Air Quality Review: West Midlands Interchange

January 2019

1.1 Air Quality Consultants Ltd (AQC) has reviewed the information submitted in relation to air quality in support of the DCO application for the West Midlands Interchange.

1.2 This report reviews chapter 7 of the Environmental Statement and associated appendices (hereinafter referred to as the “assessment”). It also takes into consideration the following documents that were received in response to an initial review of the ES chapter:

Figure 7.2.7: Comparison of final modelled NO₂ with Measured NO₂ in South Staffordshire

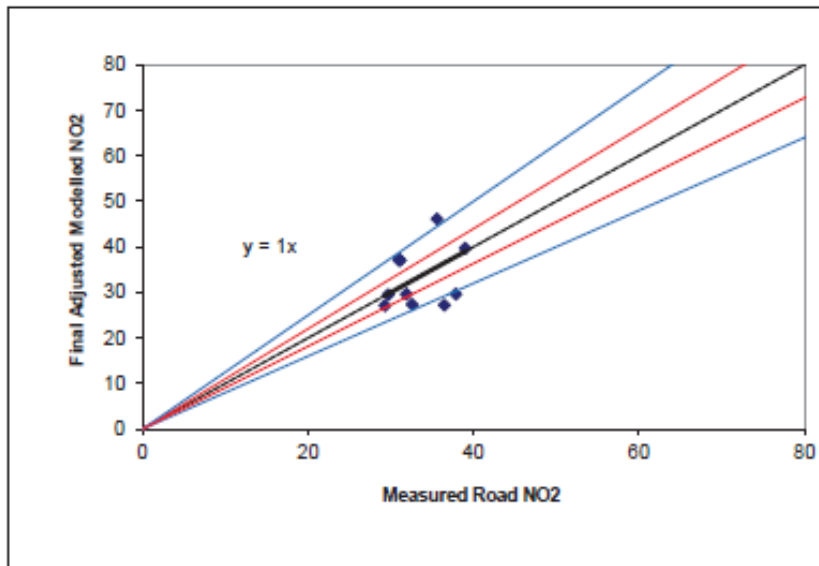
- 3.12 However, as shown in the Figure below (reproduced from the assessment), there is a large amount of scatter in the model results when they are compared with the measured values. At three of the sites, the final NO₂ concentrations fall outside the Defra guideline of +/-25%. In addition, the scatter suggests a very poor overall relationship between modelled and measured concentrations. As the actual predicted and measured values are not stated, it is not possible to evaluate the model performance against the criteria for R², RMSE and FB, as stated in LAQM.TG16; these data and calculations should be provided.

- 3.13 No model results are presented for the baseline year and it has not been possible to make a direct comparison with measurements and model predictions in the same year (other than the data points shown in the Figure). However, the results presented in Table 1 demonstrate that the predicted 2021 results at the monitoring sites (and therefore receptors) alongside the M6 are clearly too high. This is particularly apparent as 2021 concentrations would be expected to be lower than 2016 values, and in this instance they are higher.

- 3.14 As the 2015 baseline model results are not presented, it difficult to determine the extent of any under-prediction of the model at the other monitoring sites. This is particularly important for HA2 within the AQMA, which will be most sensitive to any changes in concentration as a result of the development. This may have resulted in the changes in concentrations being under-represented and could invalidate the reported conclusions.

- 3.18 The statistics and data provided are very useful to evaluate the model performance. However, contrary to the submitted response, they do not suggest the model is adequate and that there would be no change to the conclusions to the ES. The additional information provided supports reclassification of model verification from a ‘moderate’ to ‘major’ issue. The reasons for this conclusion are discussed below.

- 3.19 The correlation coefficient is reported as 0.24. The text in the table states that, “*a value of zero means no relationship and a value of 1 means absolute relationship.*” Therefore this result can be considered to demonstrate that there is only a weak relationship between the modelled and measured concentrations.

- 3.20 The RMSE is reported as 6.1 µg/m³. This means that there is a large deviation in the difference between the measured and modelled results. Ideally this value should be less than 4 µg/m³ (10% of the 40 µg/m³ objective).

- 3.21 Although the overall fractional bias is the ideal value of 0, this measure does not take into account the spread in values at specific sites. This value is just a result of large over-estimations at some sites being counteracted by equally large under-estimations at other sites.

- 3.22 The results presented in Table 1, clearly show that the over-predictions are occurring at motorway sites, and the under-predictions are alongside non-motorway roads. This is a common occurrence with the model used. The most appropriate way to address this would have been to carry out model verification separately for motorway and non-motorway roads. This would have resulted in a lower verification factor being applied to concentrations as a result of motorways, and a higher factor for other roads.

“Whilst there is some scatter in the model verification, the primary verification factor is relatively low and is typical of this type of assessment where model variation is undertaken using 11 points. The results of the model verification at the receptors is presented in Technical Note TN-170000573-AQ, Issue: 4, which is issued with this response.

Defra Technical Guidance LAQM.TG16 provides a procedure for describing model uncertainty (Box 7.17), which is summarised in the table below along with the calculated values for the SSDC verification.

The statistical analysis indicates that there is a positive correlation between the predicted and monitored data, albeit not a strong one. The average error is also relatively large, but there is no overall tendency for the model to over or under predict.

The comparison of monitored and predicted data for the receptors adjacent to the M6 does suggest that the model is over-predicting concentrations at the receptors adjacent to the motorway. As the highest concentrations are predicted for receptors adjacent to the motorway, this suggests that the overall assessment is conservative. We would therefore agree that the moderate and substantial adverse effects predicted in the ES for daily mean PM₁₀ concentrations adjacent to the motorway at Darlaston Road, Walsall District are unlikely to occur.

For monitoring point HA2, the predicted concentration in 2016 is 29.6µg/m³ versus a monitored concentration of 37.9µg/m³. Whilst the model is underpredicting at this location, as noted in the AQC review, concentrations would be expected to be lower in 2021 (and in future years) compared to 2016 values. This is demonstrated in the modelling results at HA2 which show baseline NO2 concentrations of 21.6, 14.5 and 13.6µg/m³ in 2021, 2028 and 2036 respectively. The corresponding with development concentrations are 22.0, 14.9 and 14.0µg/m³ respectively. Even

allowing for model under-prediction at this location, there would be no exceedance of the annual mean NO₂ objective at this location and therefore no change to the reported conclusions.”
